**Lead Local Flood Authority**  
**Post Point CHN 215**  
**Hertfordshire County Council**  
**County Hall, Pegs Lane**  
**HERTFORD SG13 8DN**

Date 28 October 2022

**RE 6/2022/1853/MAJ - Eisai Europe Limited, European Knowledge Centre, Mosquito Way, Hatfield, AL10 9SN**

SHEET TITLE
EML FACILITY EXPANSION
PROPOSED SURFACE WATER
DRAINAGE LAYOUT
OPTION 2

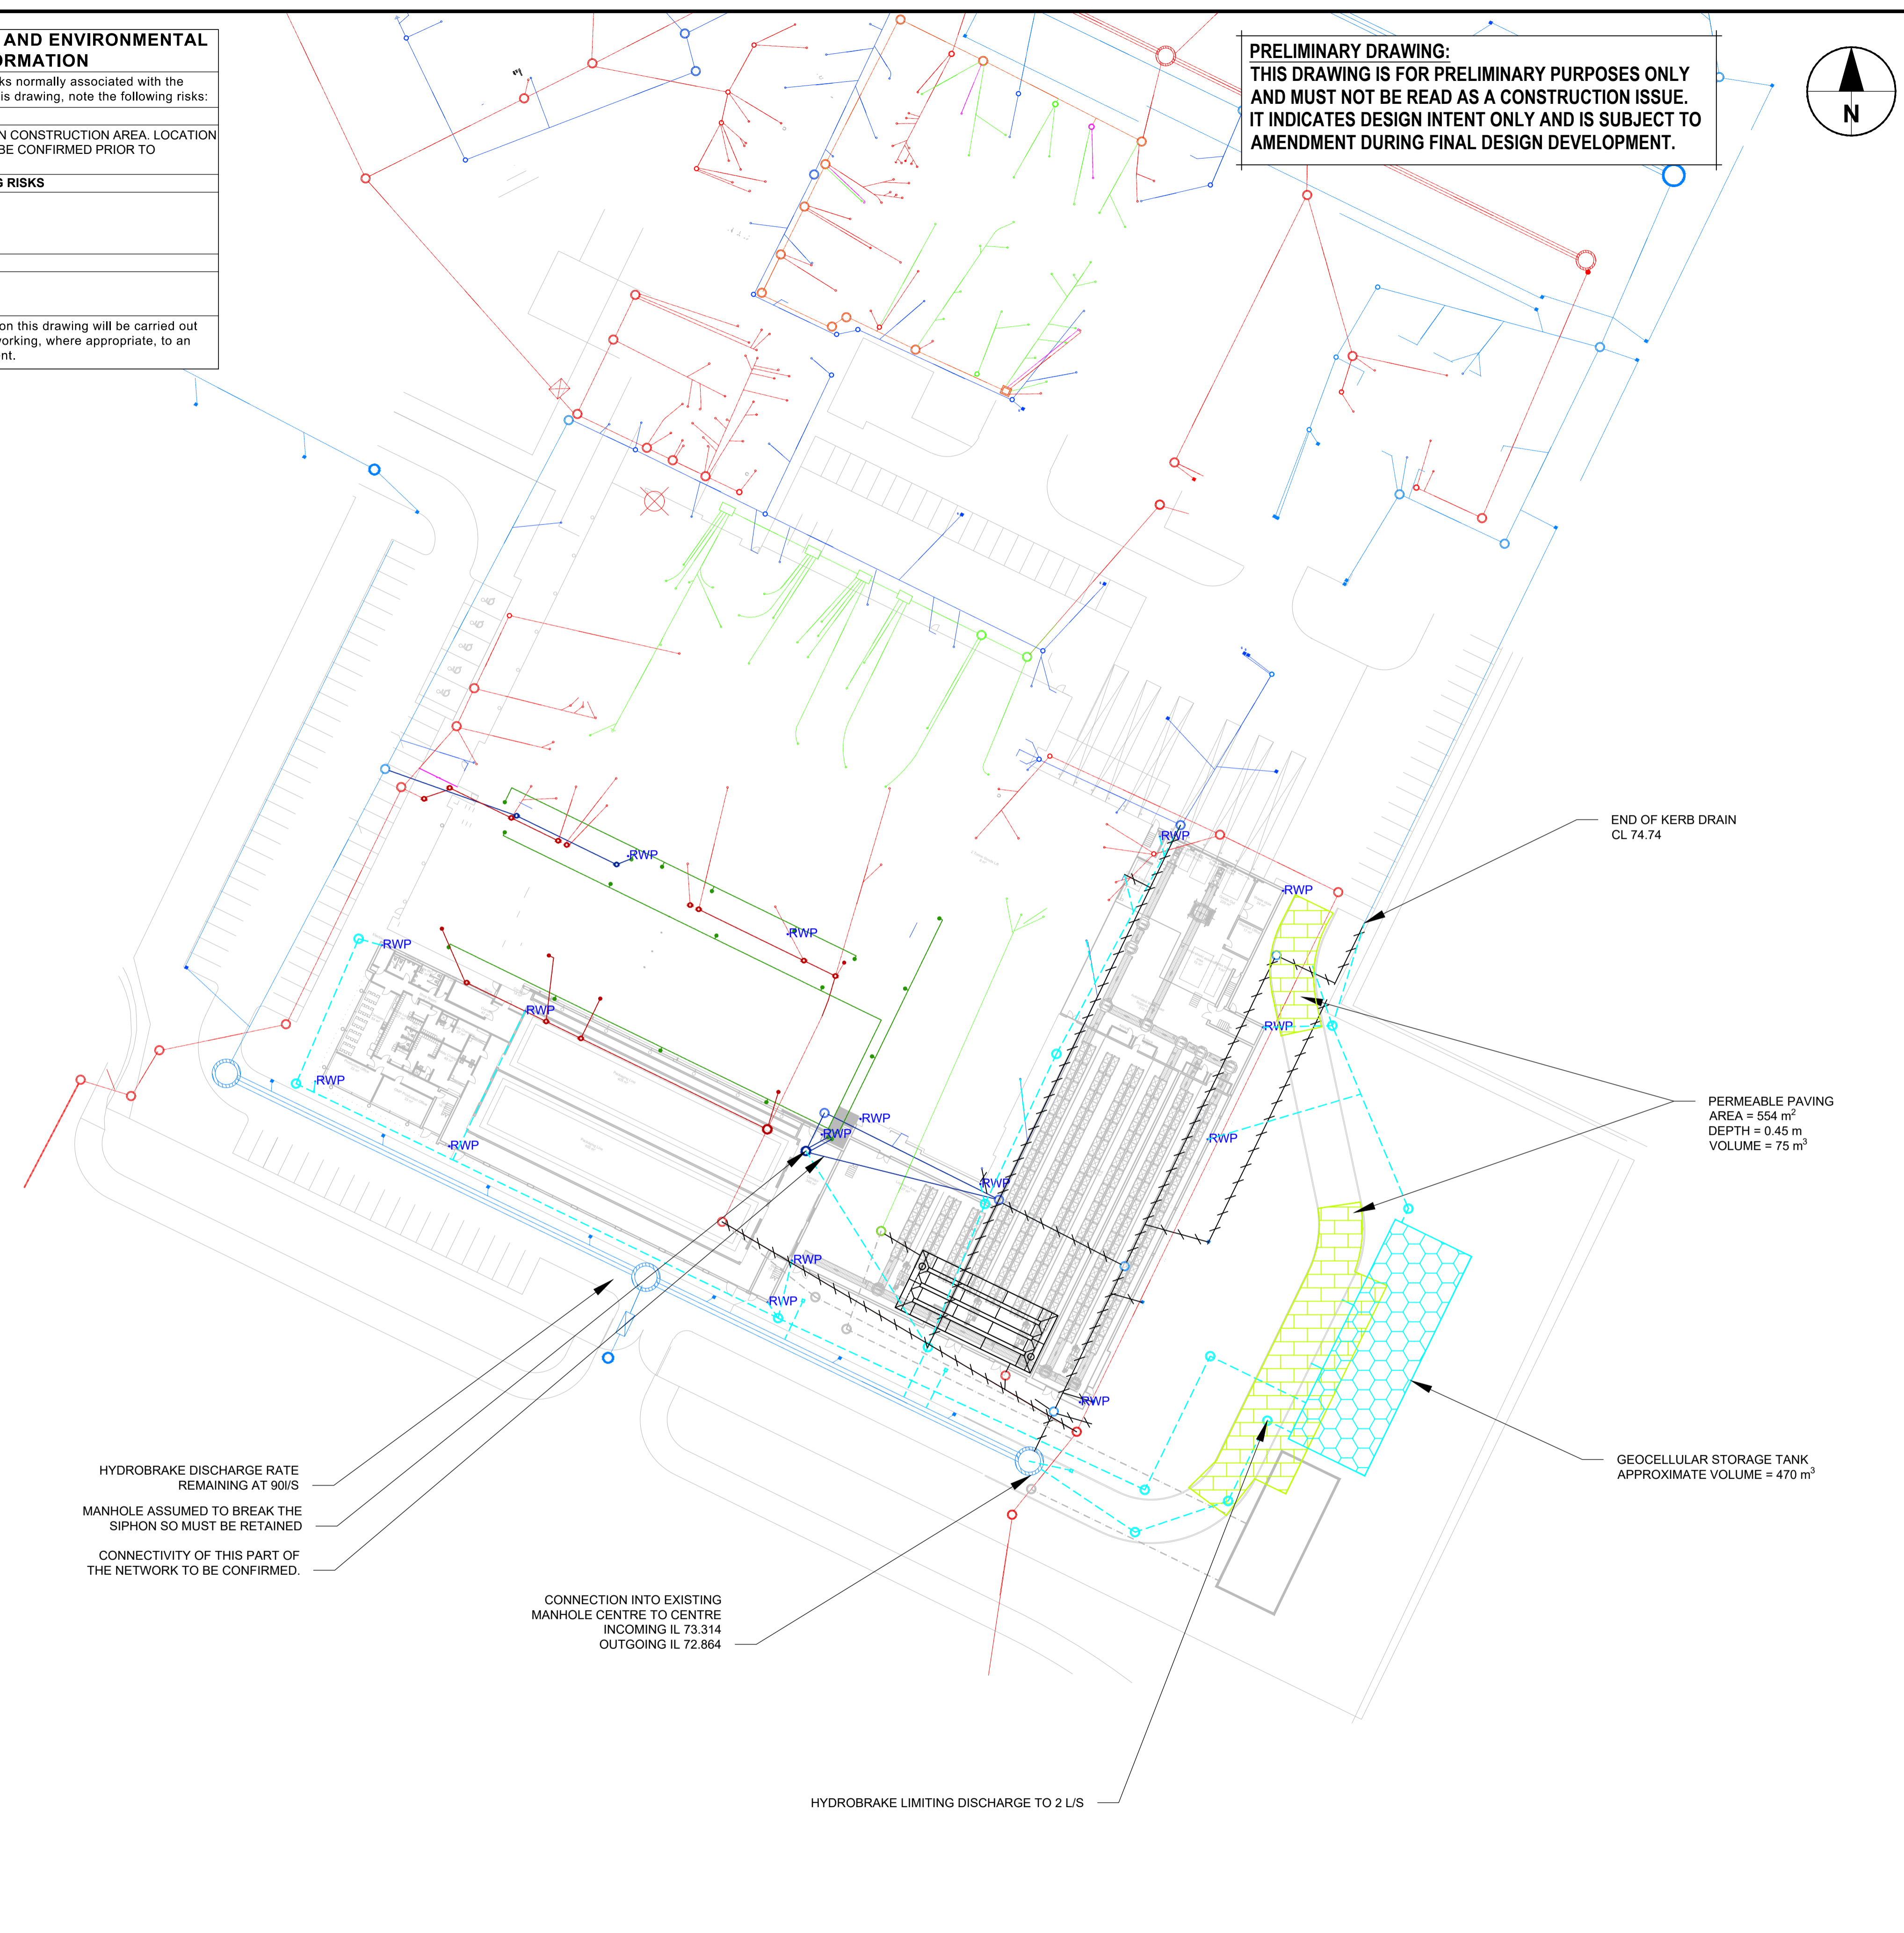
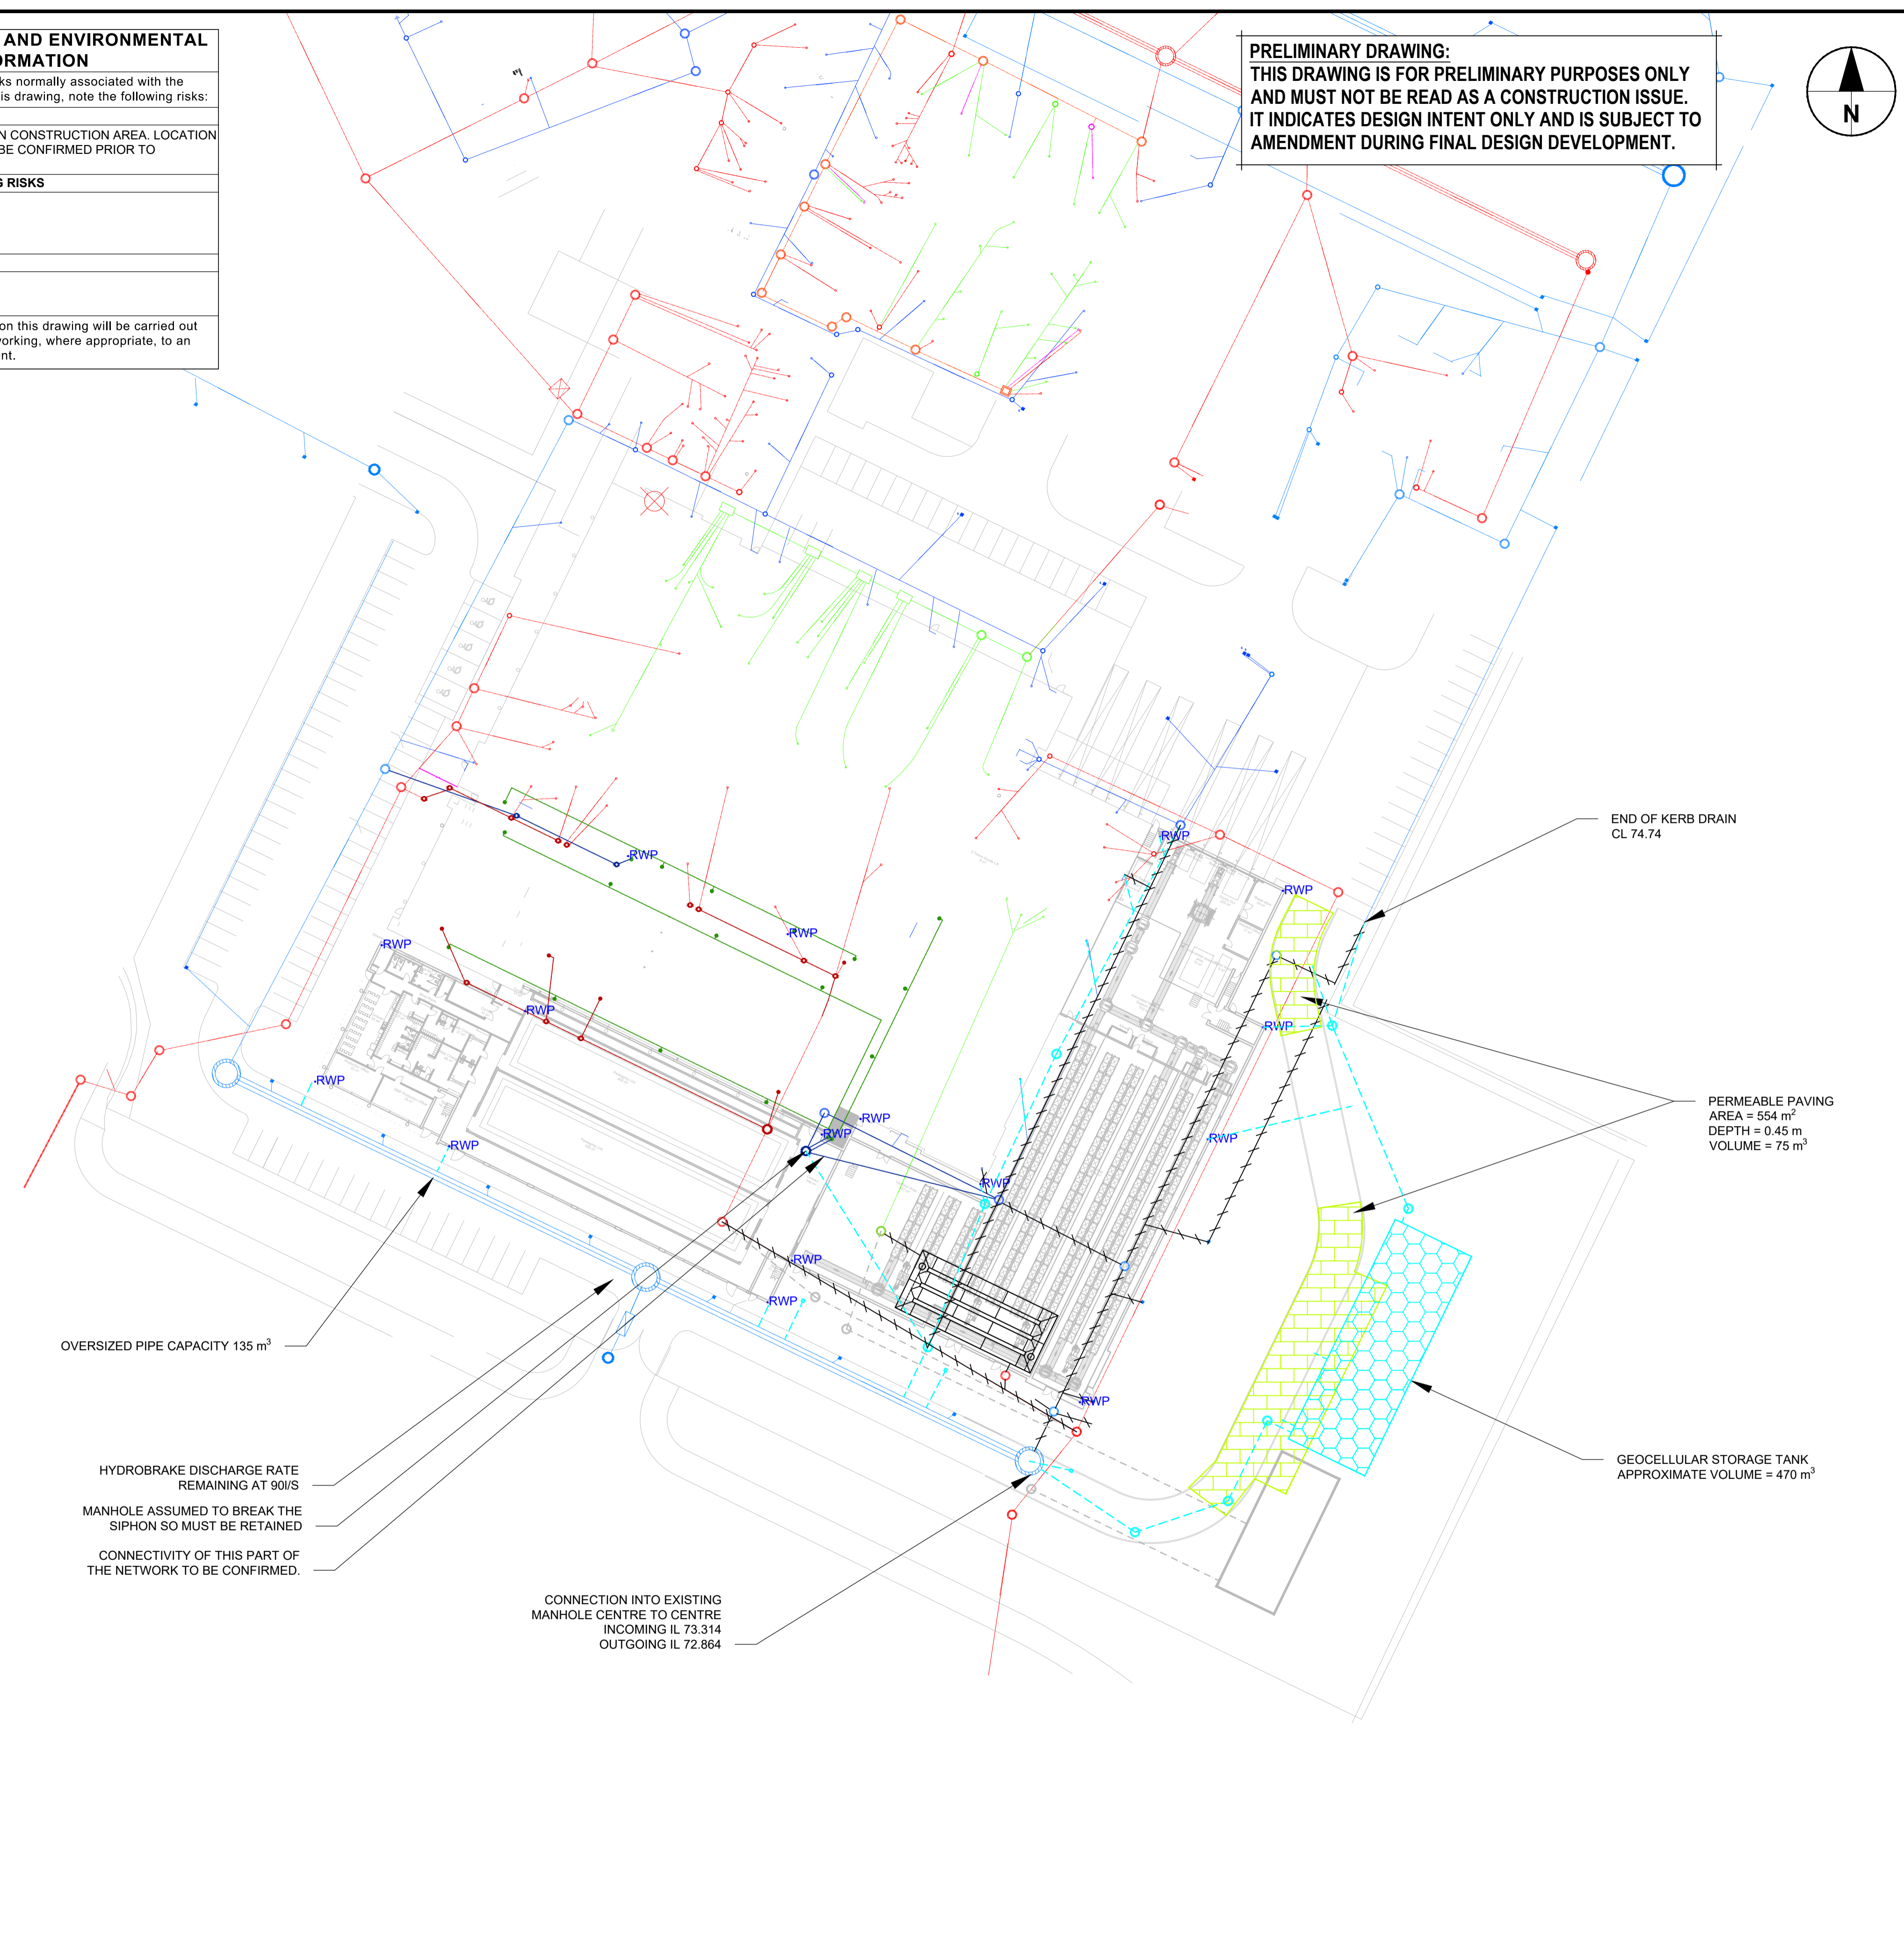
- e. Three different drainage strategy options have been provided. No definite solution has been identified and no discussion around the different approaches was undertaken with Thames Water. As this is a full planning application a single drainage design should be submitted that identifies specific details of the design including conveyance and storage elements of the network. Quick Storage estimate is not acceptable. Details of pre and post development runoff rates and volumes should be evidenced. We request that the discharge is limited to greenfield runoff rates and volumes unless lower rates to prevent surcharge of the existing drainage system is required. Evidence of this assessment should be submitted and a in principal agreement with Thames Water if the development will increase the current discharge or creating a new connection to their network.
